AW/250/19/HH

The application relates to the provision of 'hardstanding' to the front of a property located within the Craigweil House Conservation Area. The conservation area follows the boundary and layout of the estate as prepared by the architect, J.Auty. Most of the estate still bears the sense of being laid out as one unified piece, the street landscape and tree framework intending to create the rather "Arcadian" setting for house designs that would echo after the arts and craft and Tudoresque, and the 1930's aspirations - "a house in the country by the sea".

Proposed

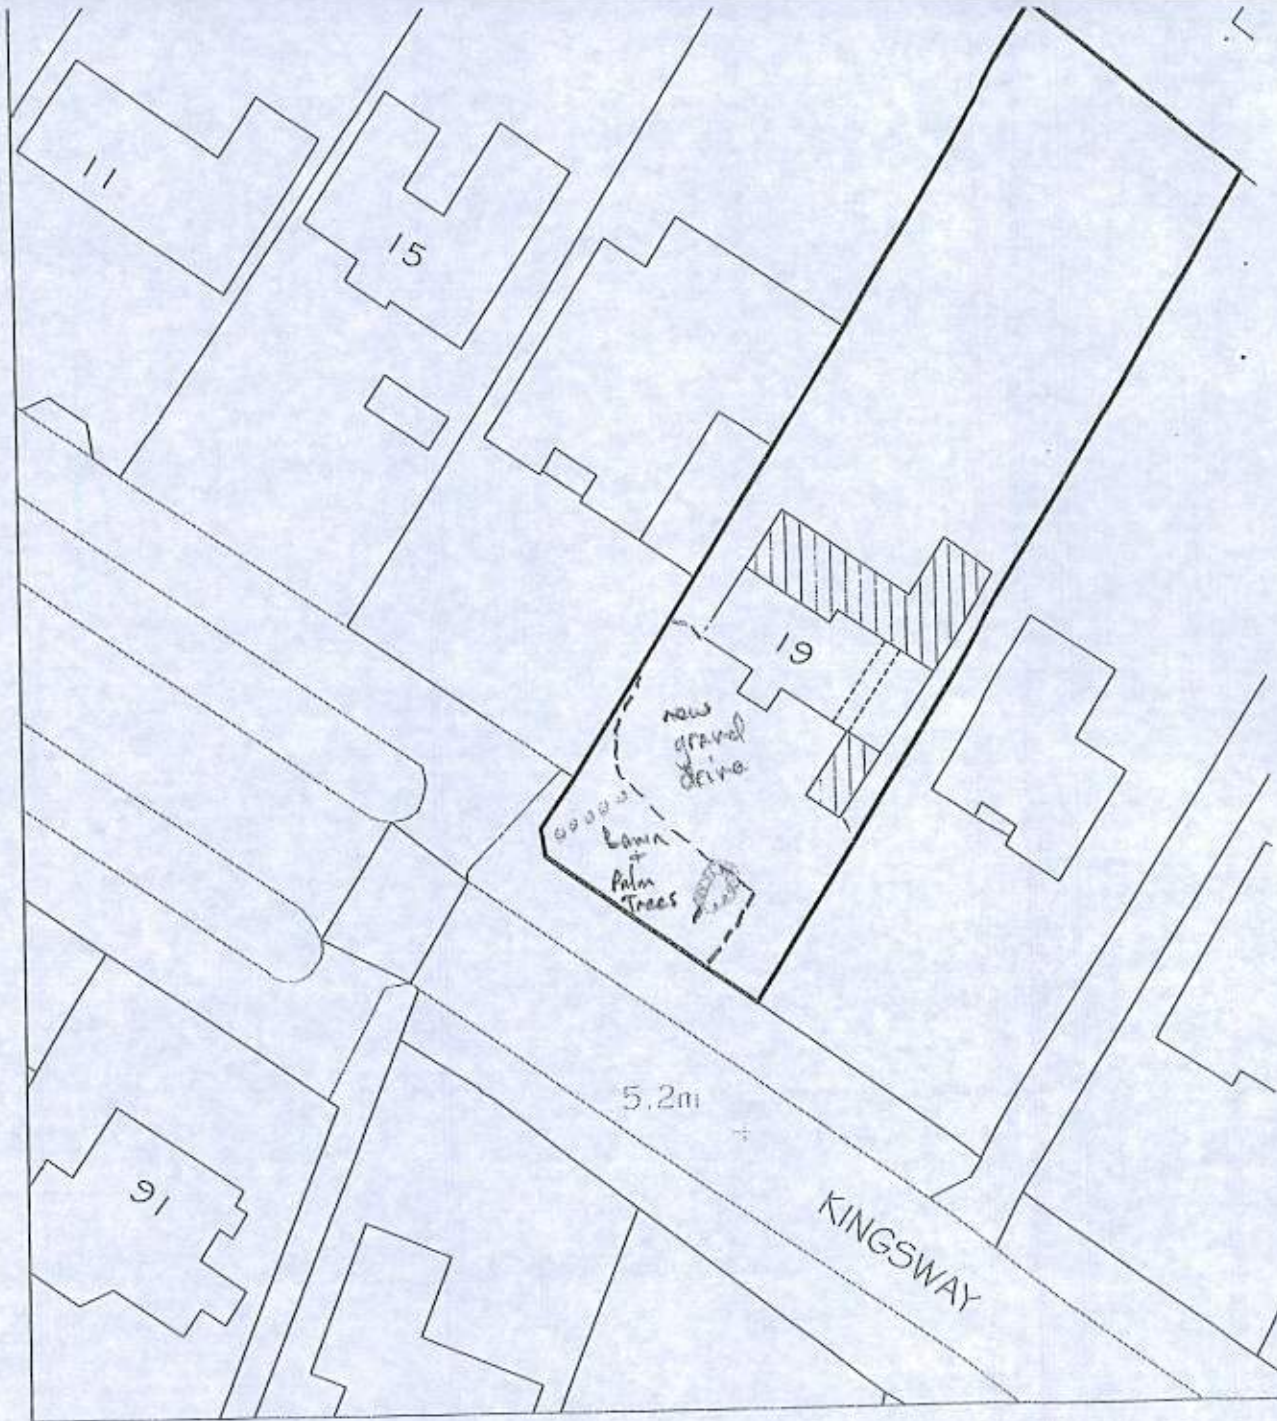
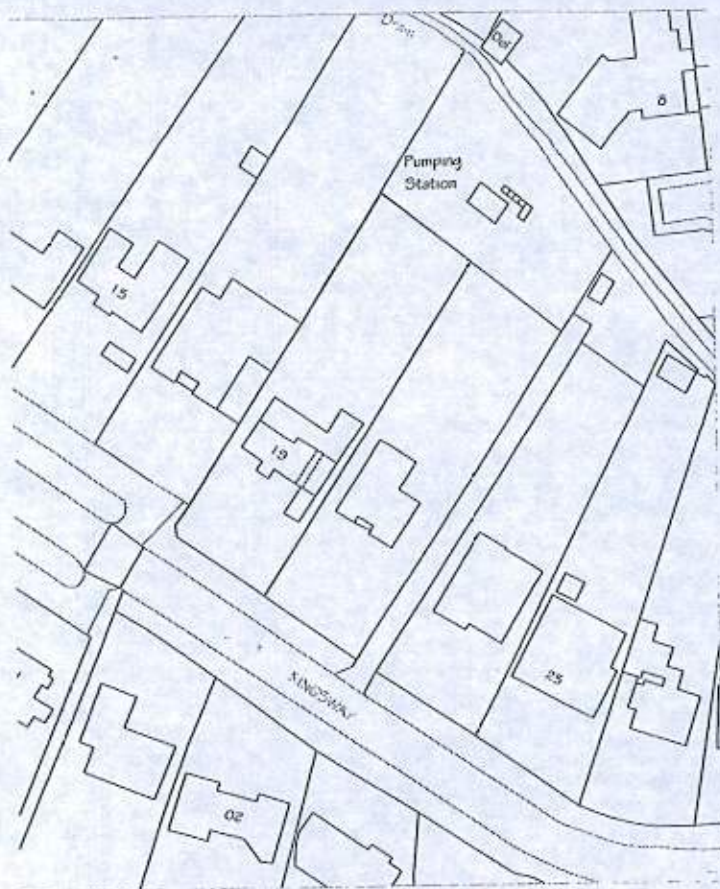
In this instance, the application is to replace a large part of the grassed area with gravel hardstanding and occasional palm trees and associated shrubs. This will create a more tropical feel to the amenity space.

There is some concern regarding the size of the garden to be covered by the parking area, as it could result in the front garden looking more like a residential car park as opposed to amenity space. It might be that if a carefully landscaped plan is prepared that the impact of the parked cars could be reduced, whilst ensuring that the 'green' character is maintained. Whilst an indicative sketch has been provided, you may wish to have further information regarding the planting scheme in order to provide certainty as to what will actually be installed.

However, on balance, it is considered that the concept of a larger drive is considered to be acceptable, and to not cause harm to the significance of the heritage assets or their setting. As a consequence, it should be determined in accordance with the relevant policies within the Development Plan, along with these comments
